6 August 2015

**Re: Letter of Strong objection to Staged Concept Proposal SSD6454- by SCECGS
Redlands 272 Military Road, Cremorne**

Drawing Title
SHADOW DIAGRAMS PROPOSED - SOLSTICE JUNE 21

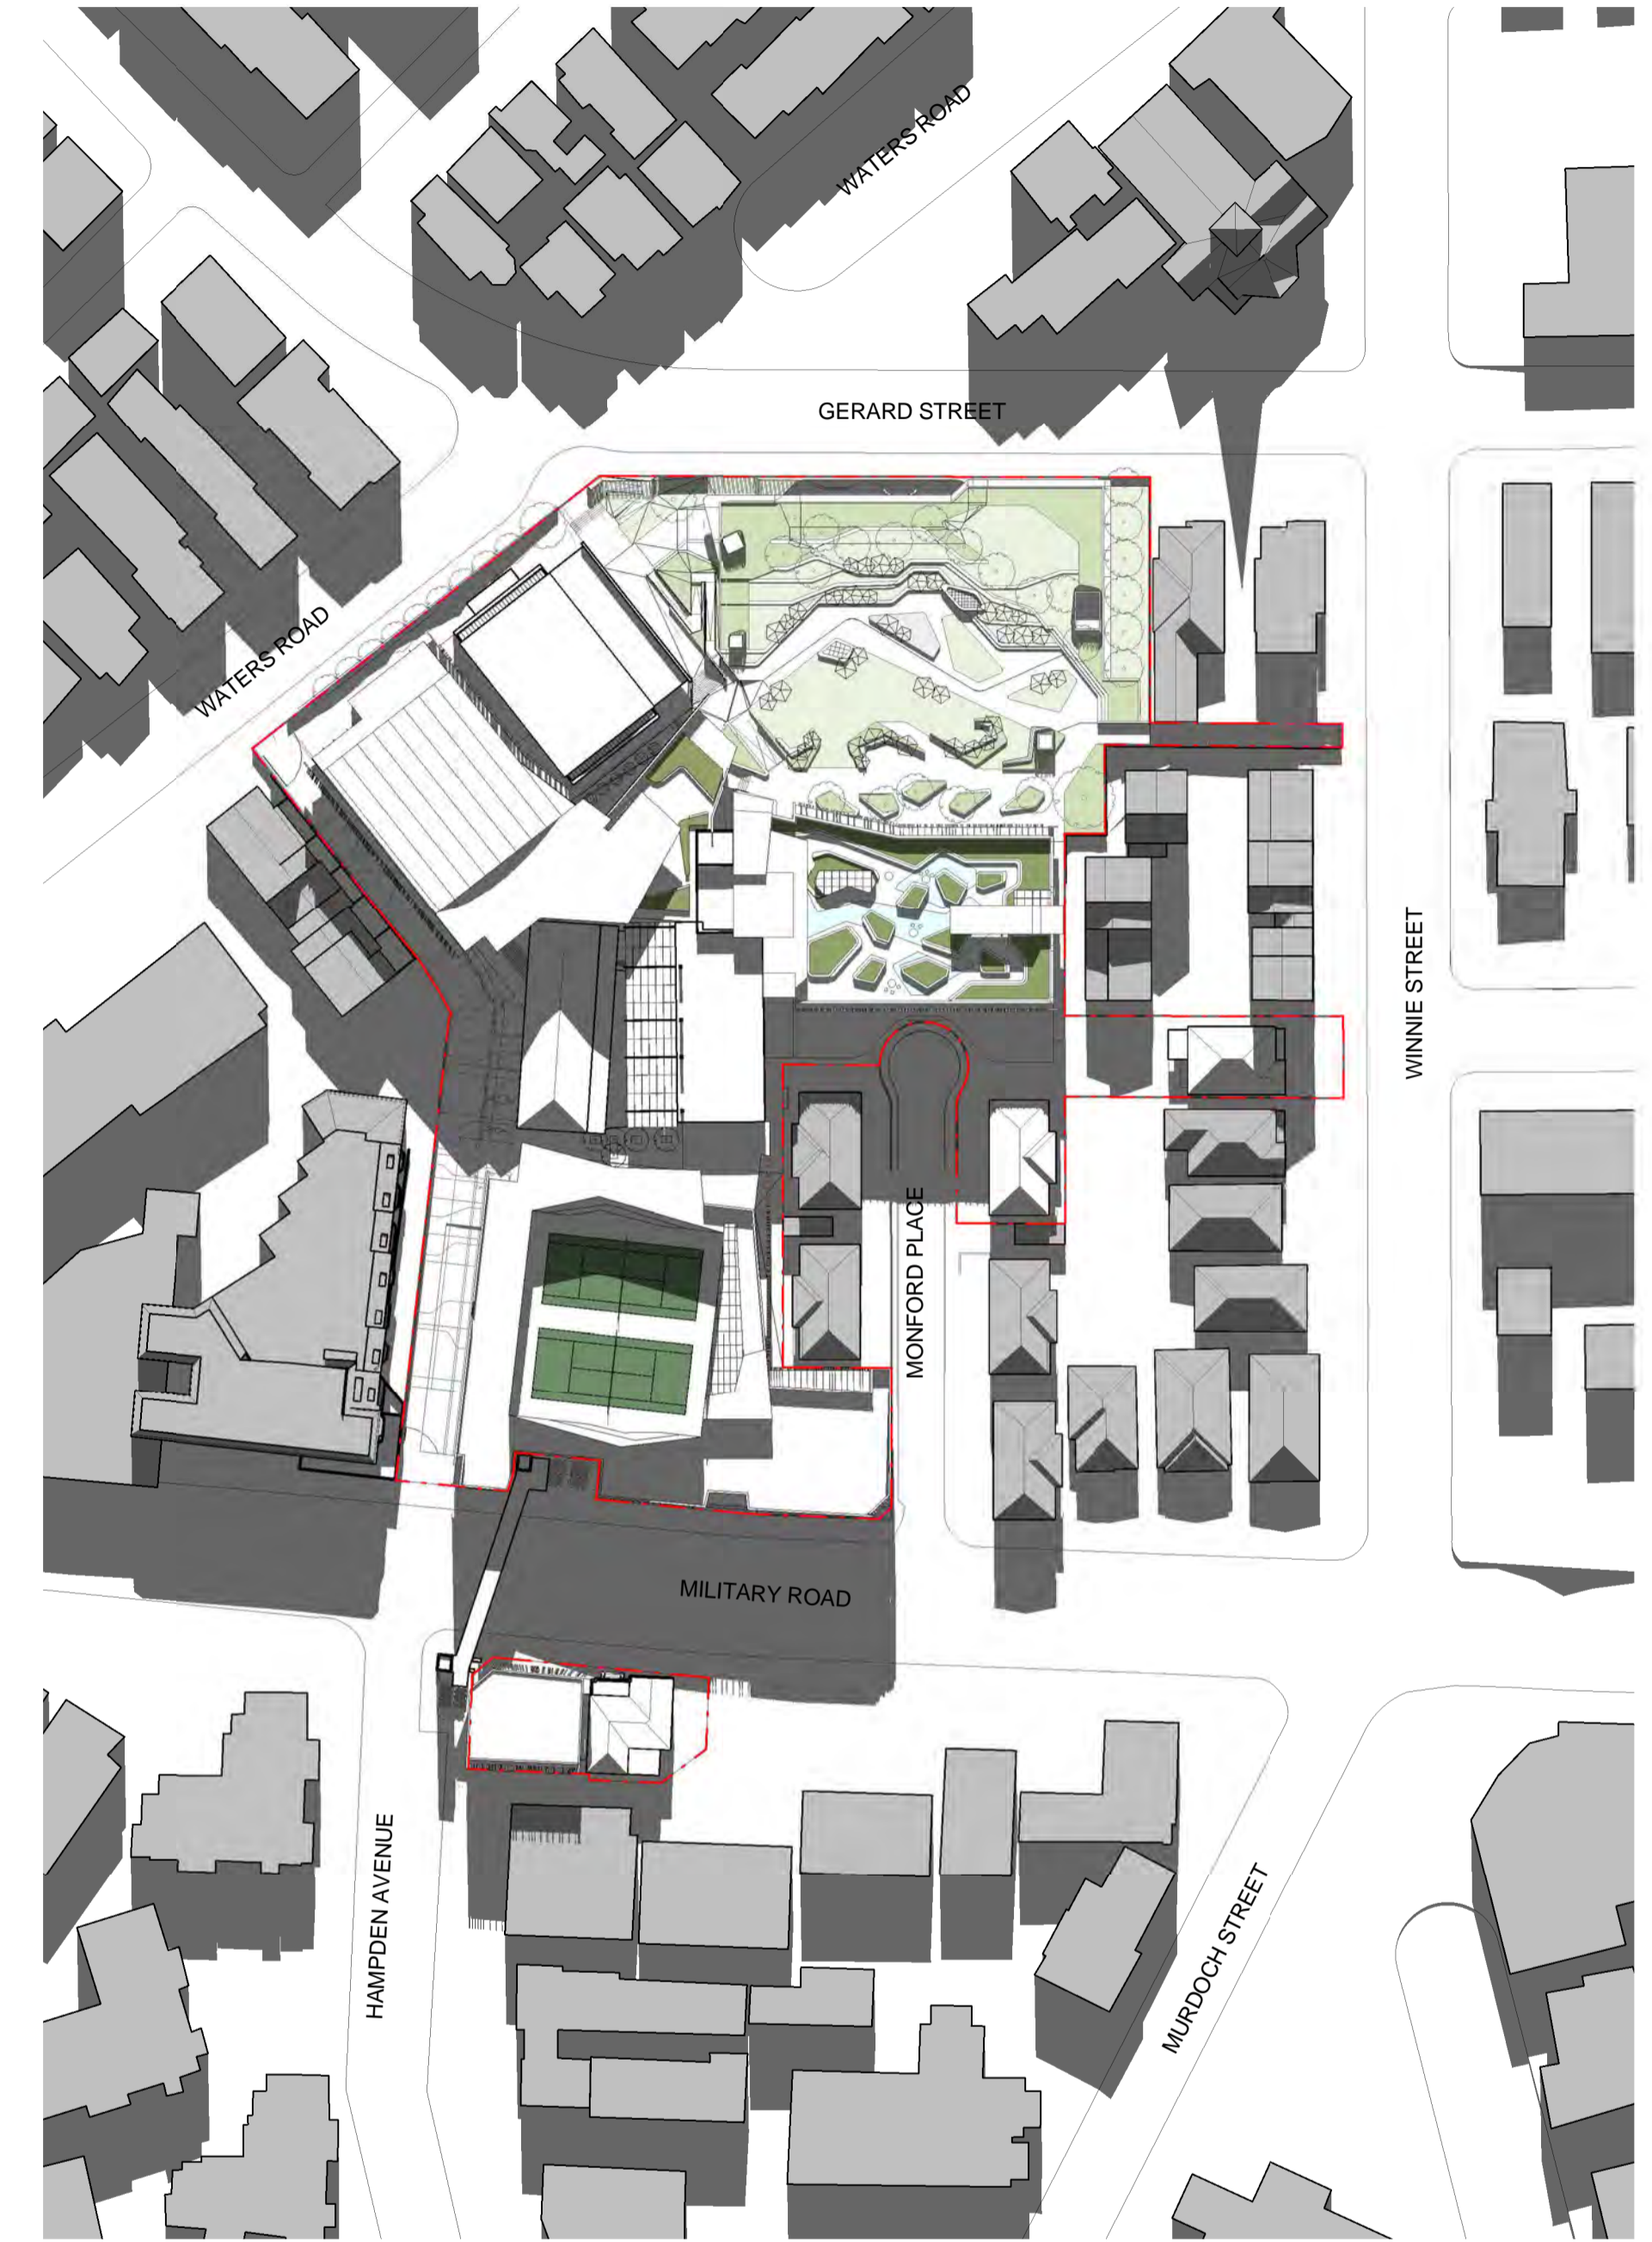
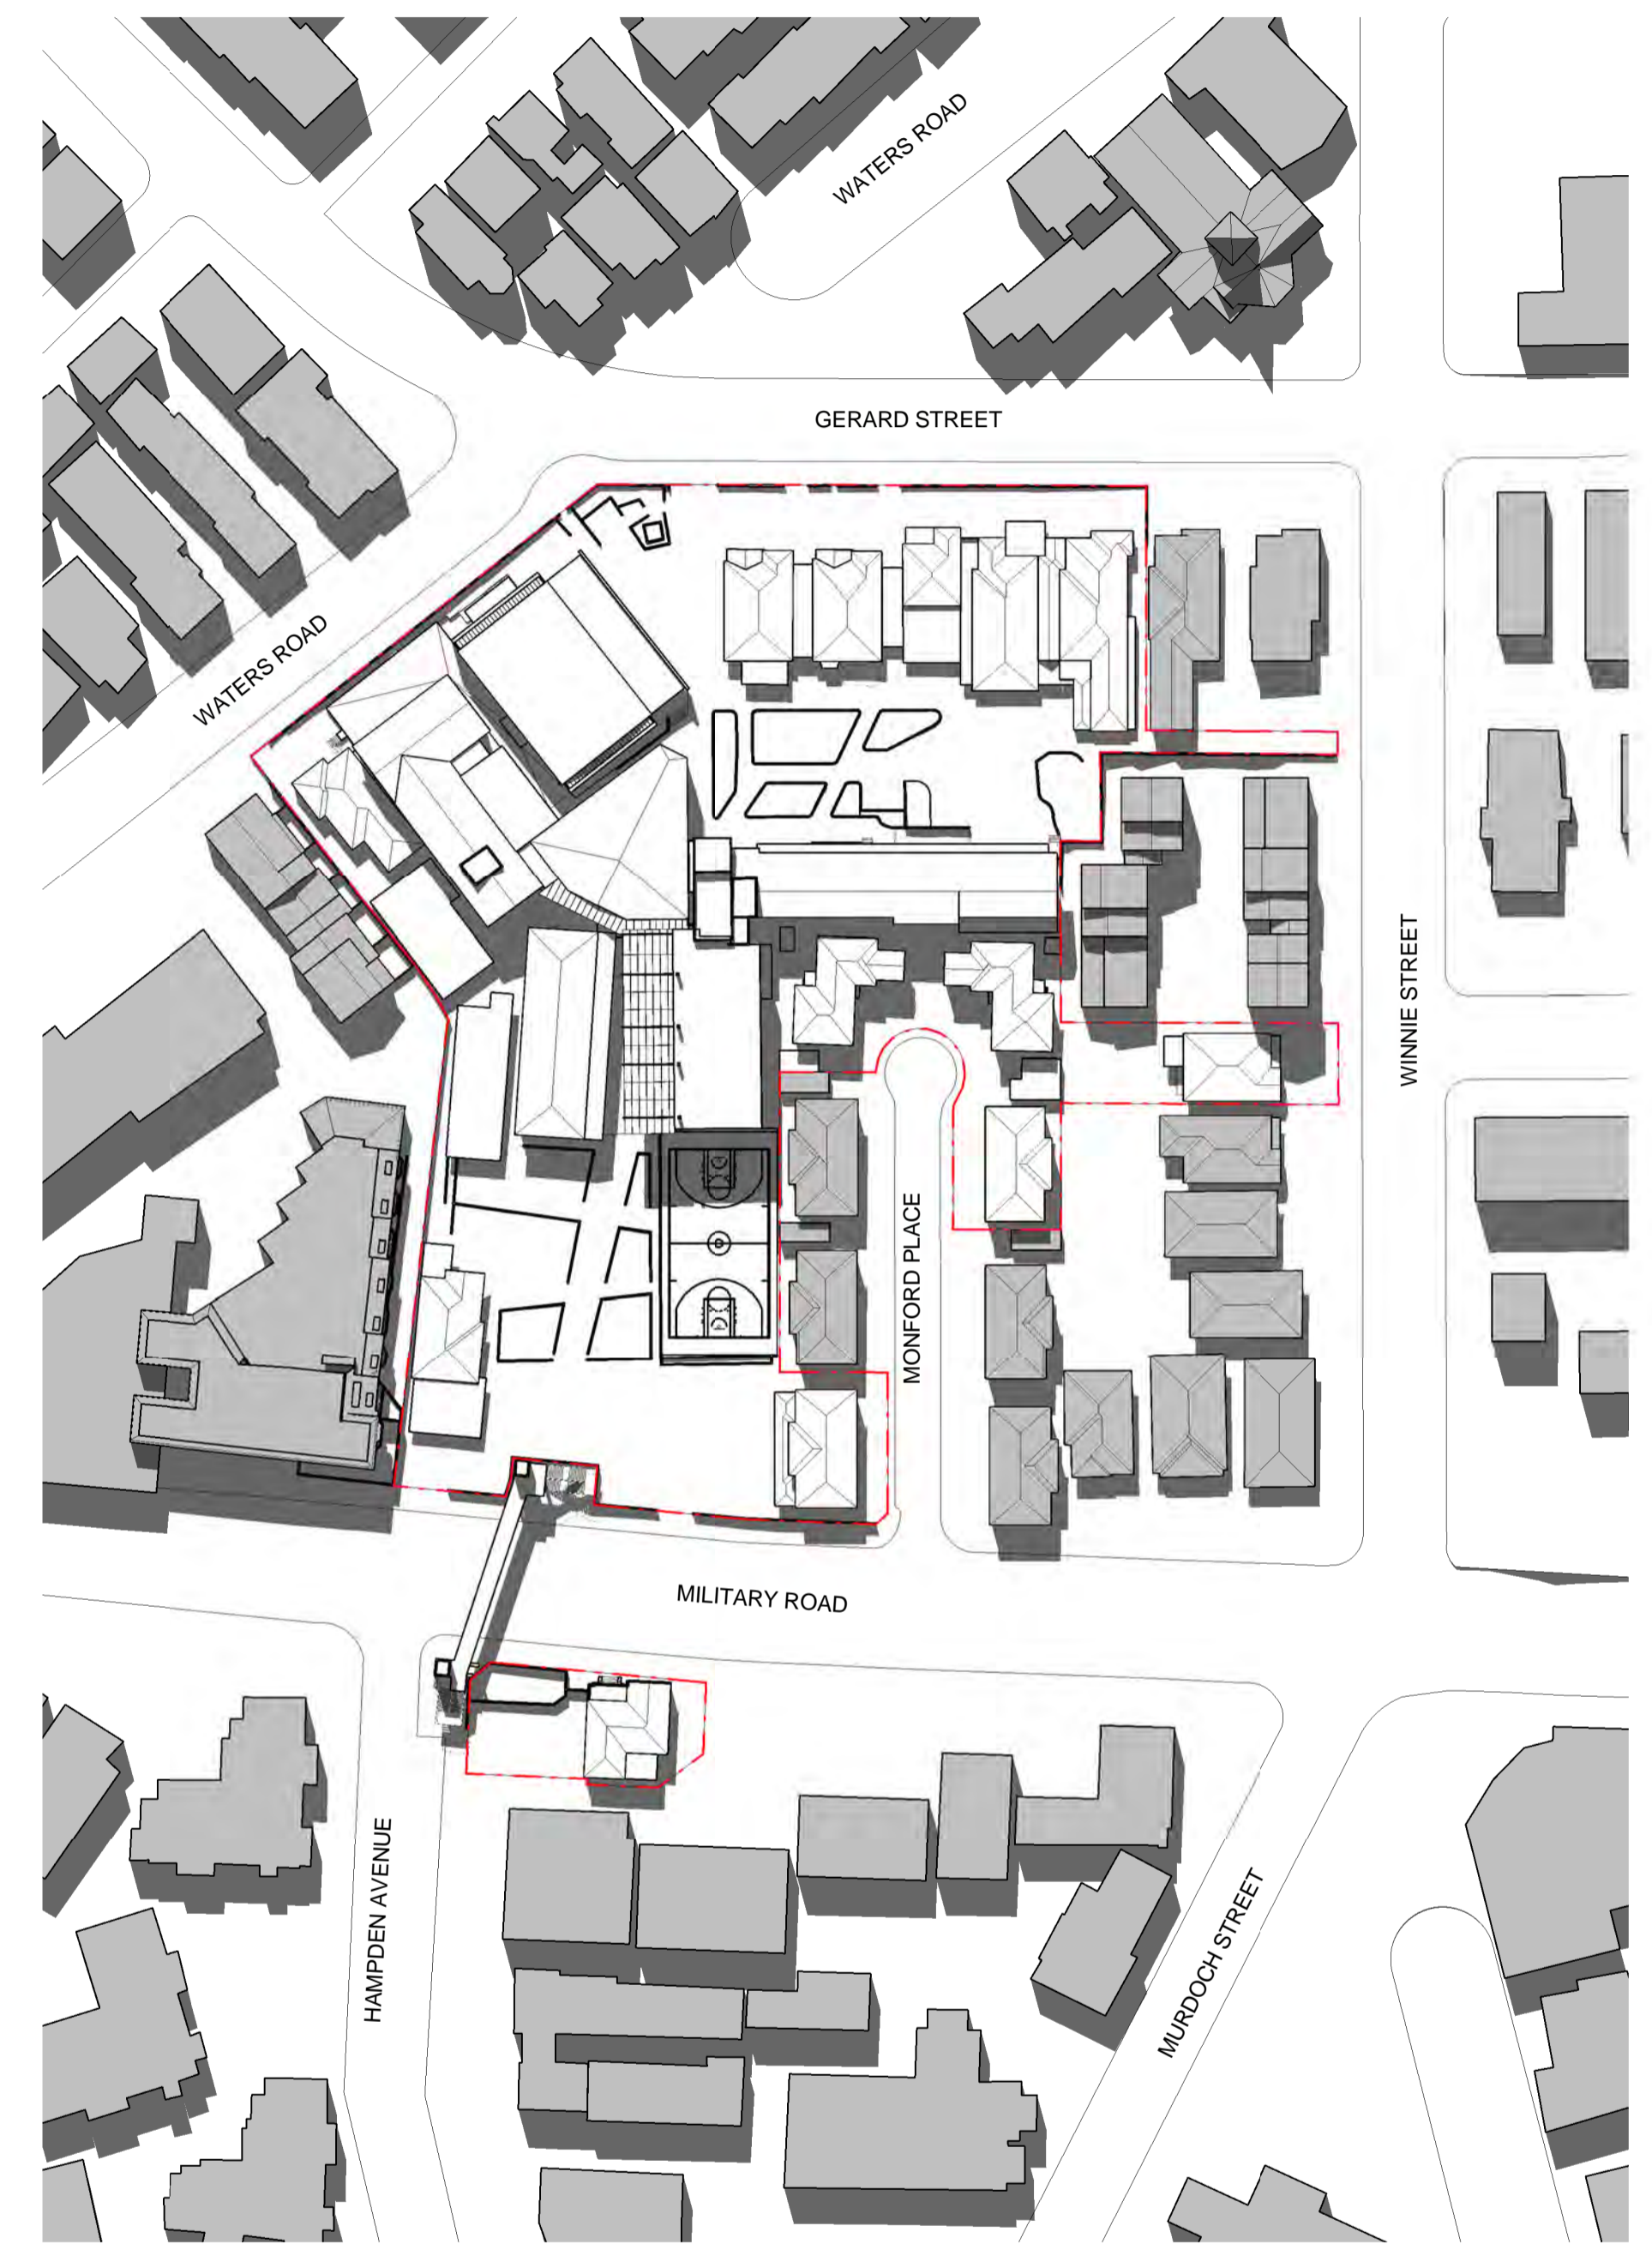
One component of the documentation and plans is a series of "shadow diagrams".

These show the shadows cast by the school's building at key times of the year (the 2 solstices and 2 equinoxes). They show the shadows cast by the existing buildings, and also the shadows cast by the proposed buildings.

The diagrams show that there will be a significant amount of extra shadow cast by the proposed buildings along our common boundary. As the result, none of the residents and units will receive sunlight all seasons, especially winter. I am afraid the proposed new builds will threaten our right to sunlight.
